From: Sue Howell <Sue.Howell@arun.gov.uk>
Sent: 13 October 2022 12:22
To: Planning.Responses <Planning.Responses@arun.gov.uk>
Cc: Katie Sharp <Katie.Sharp@arun.gov.uk>
Subject: Planning Consultation on: A/48/22/RES - Revised consultation 13/10/22

Response to Planning Application Revised comments 13/10/22

Application ref: A/48/22/RES

Location: Land off Arundel Road Angmering BN16 4ET

Title **Planting Plans**
6 of 6

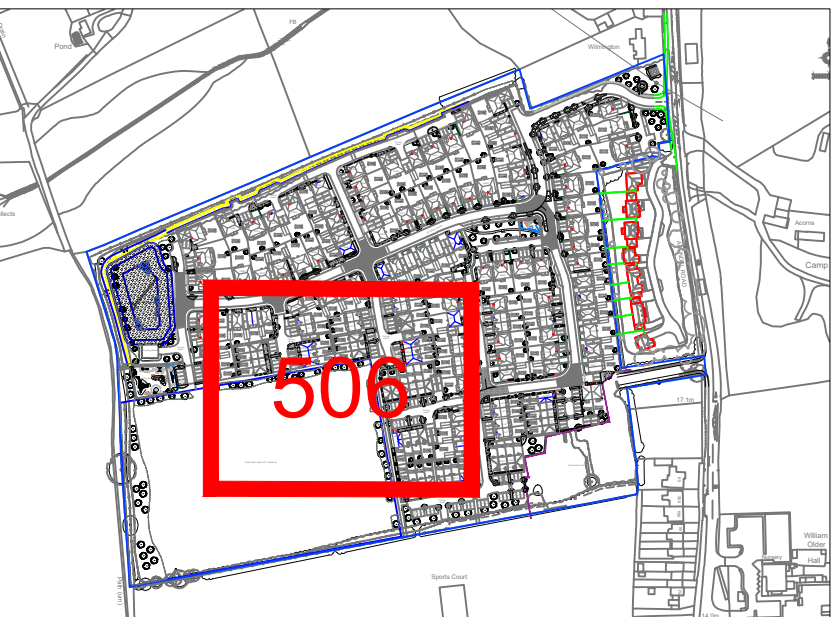
The Planting plans 2 of 6 502 Rev B and 6 of 6 506 Rev B – Sports Pitch layout poses potential conflict between the pitches and the shown Buffer Mix and Woodland Edge Mix planting on three sides of the POS. The pitch layouts will need to be superimposed onto these planting layouts to ensure that run off perimeters are observed and that the planting will not impede these margins.
